WEST SUSSEX COUNTY COUNCIL CONSULTATION

TO:	Arun District Council FAO: K Welch
FROM:	WSSC - Highways Authority
DATE:	23 December 2021
LOCATION:	8 Beagle Drive Arundel BN18 0NY
SUBJECT:	F/25/21/PL Retention of prefabricated concrete workshop at rear with rear access onto Lewis Lane & realignment of the rear boundary (resubmission following F11/21/PL). This application is in CIL Zone 2 (Zero Rated) as other development.
DATE OF SITE VISIT:	n/a
RECOMMENDATION:	Advice
S106 CONTRIBUTION TOTAL:	n/a

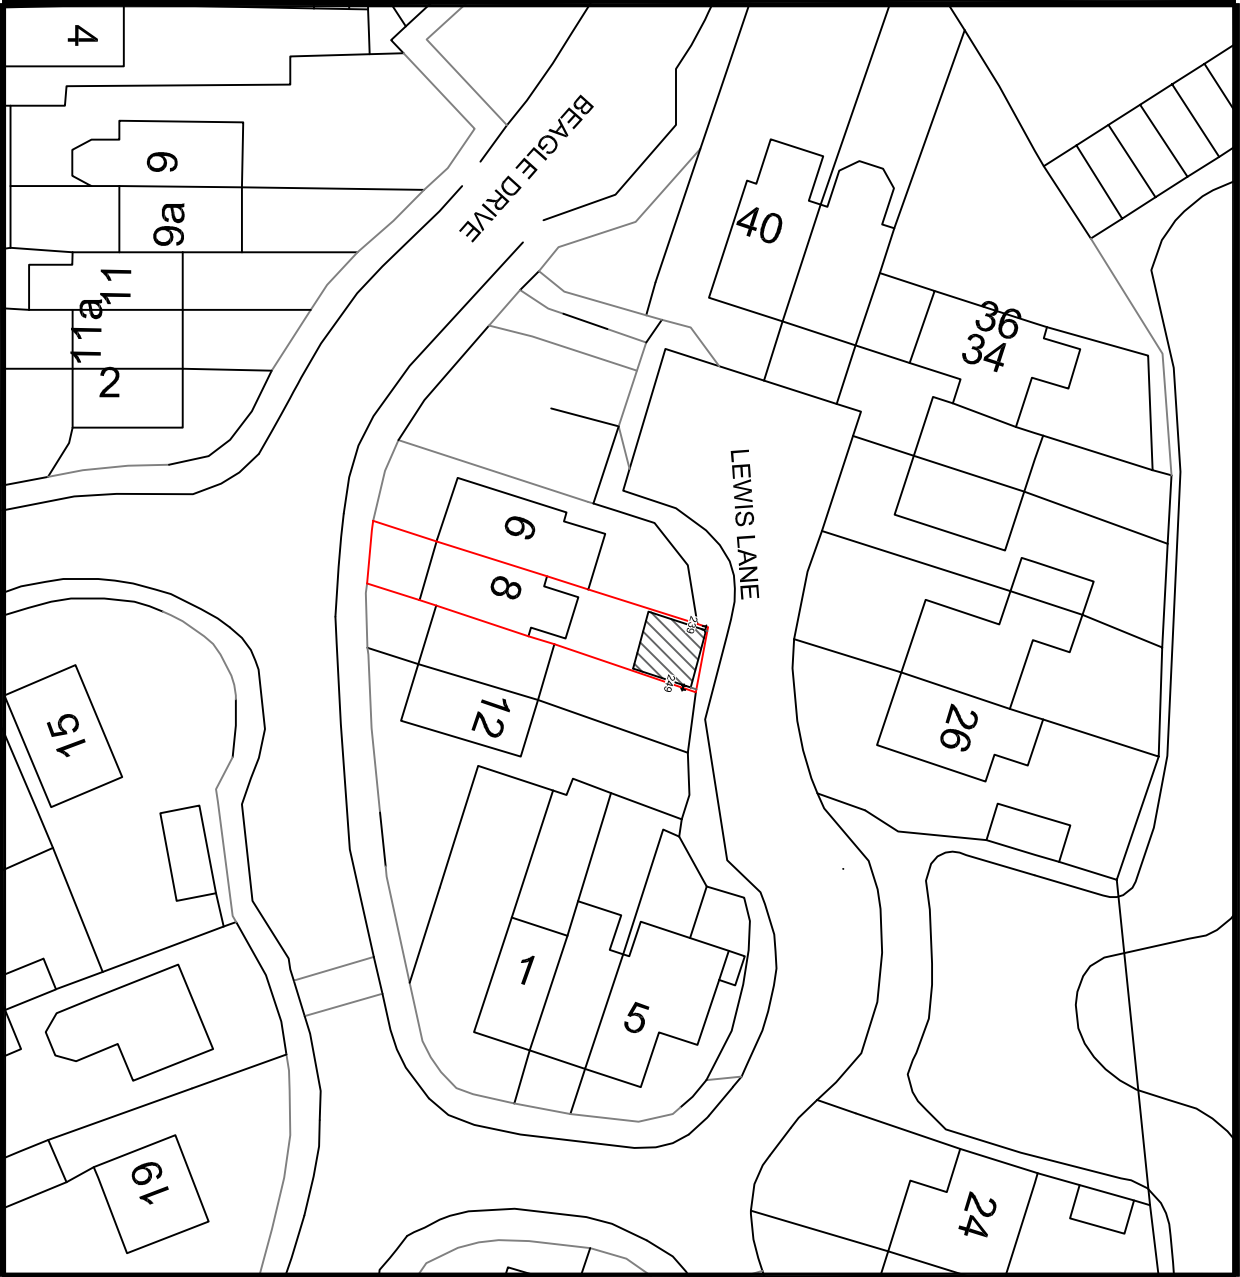
The pedestrian door which has replaced the previous garage door appears to open outwards. Ideally this should be amended to be an inwardly opening door.

It appears that the rear boundary of the site has been relocated without obtaining planning approval and as such this application seeks to regularise the situation - the land in question now houses the workshop that has been erected on the site. The LHA has established that the depth of land considered to be highway boundary extends 1.8m from the back edge of the carriageway. If the proposed workshop falls within land considered to be public highway, in order to avoid enforcement action, this will require Stopping Up to legally remove the highway rights.
